**Application by Highways England for M54 to M6 Link Road
Response to The Examining Authority's 2nd Written Questions and requests for information (ExQ2)
Issued on 4 Dec 2020**

**Response Deadline D4 8th Jan 2021
Responses From: Allow Ltd**

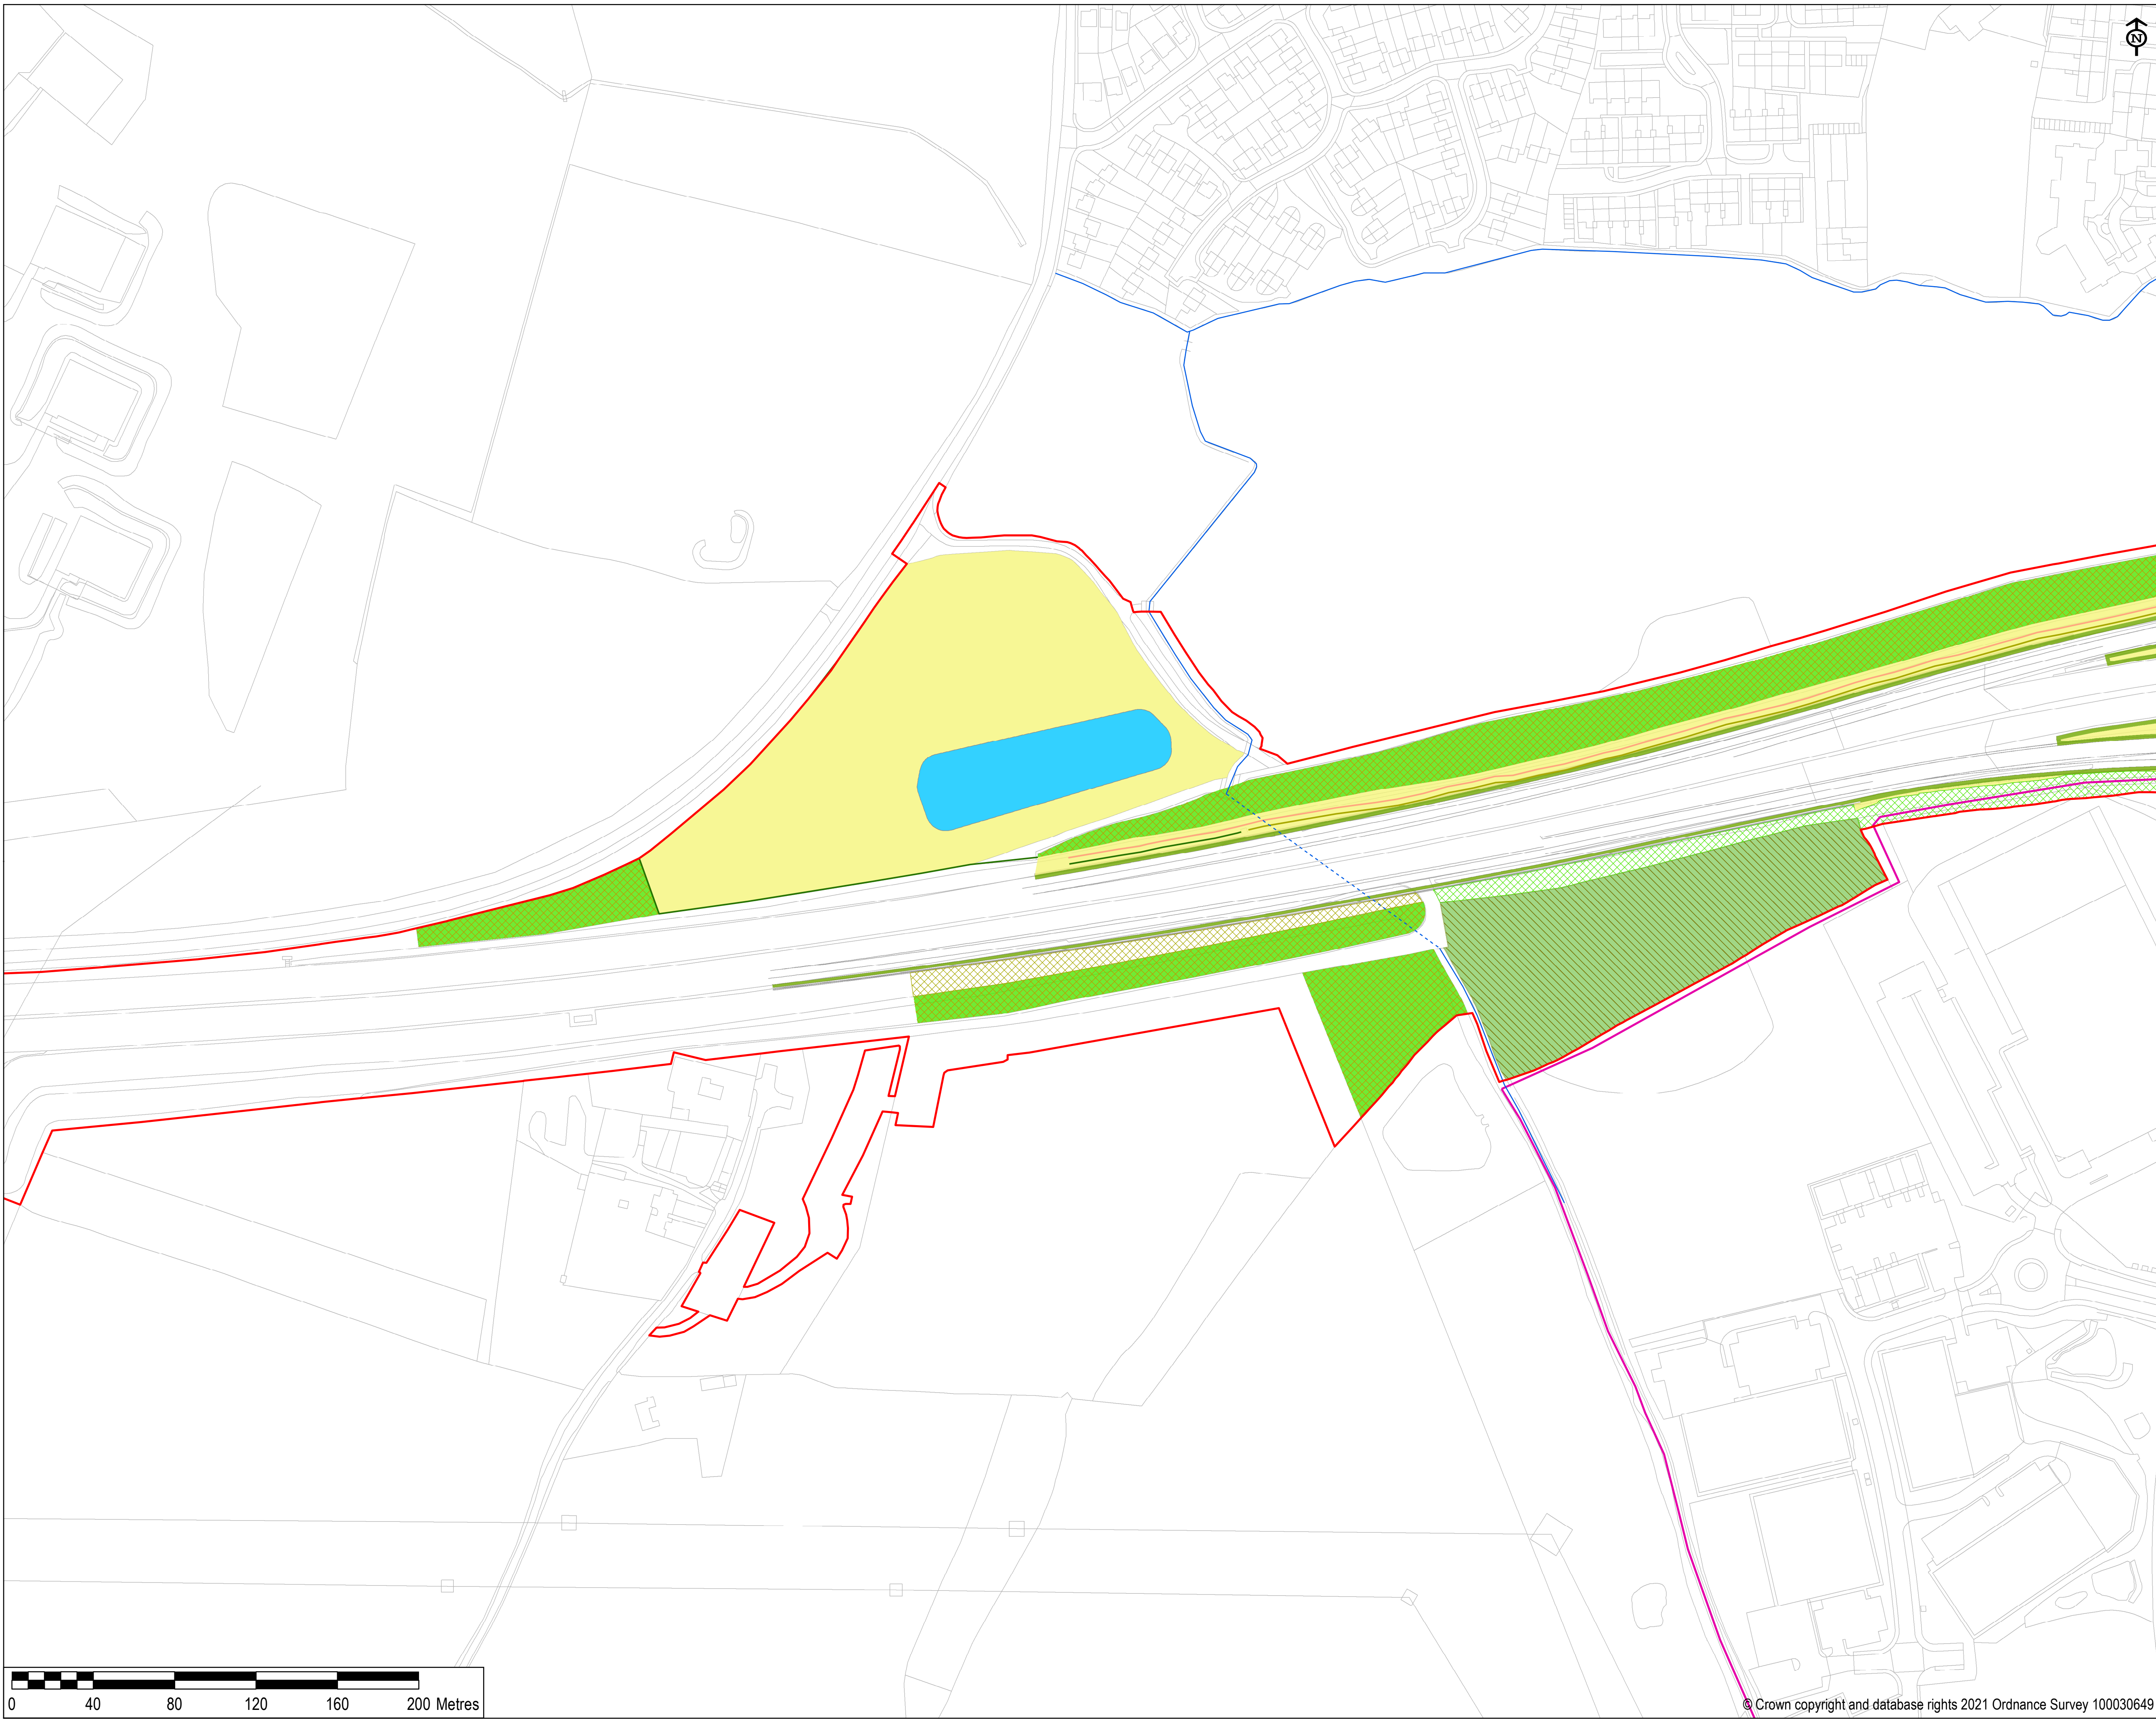
Plot SW06 on Environmental Masterplan Mitigation Breakdown, is proposed to screen views from Dark Lane. This is to address the distant views of the double roundabout and slip roads to the south of the scheme, near J1. There will be screening immediately adjoining the base of the embankments at those locations with EW 10, 11, 12 & 13. It is assumed therefore the purpose of SW06 is to offer some near distance screening for the residences of Dark Lane. We would pose the question of whether a woodland strip of 22m to 25m in width, (widening to approximately 65m in the south eastern corner adjoining the motorway,) is necessary to achieve this. It is suggested, and more conventional for, the screening planting to be a narrower width of approximately 10m which should still provide the required level of screening. It is proposed that a new hedge EH 14 would also be planted along the southern edge of the track that runs from Lower Lodge, and another along Dark Lane itself at SH08, therefore these would also afford some additional screening at a lower height level.

We have not seen any ecological justification for planting on 4/20C, therefore would suggest that this middle distance planting could be reduced in width to 10 m to reduce the area of productive agricultural land taken from Allow Ltd.

Plan 1 attached illustrates an alternative 10m width of planting alongside the Lower Lodge driveway.
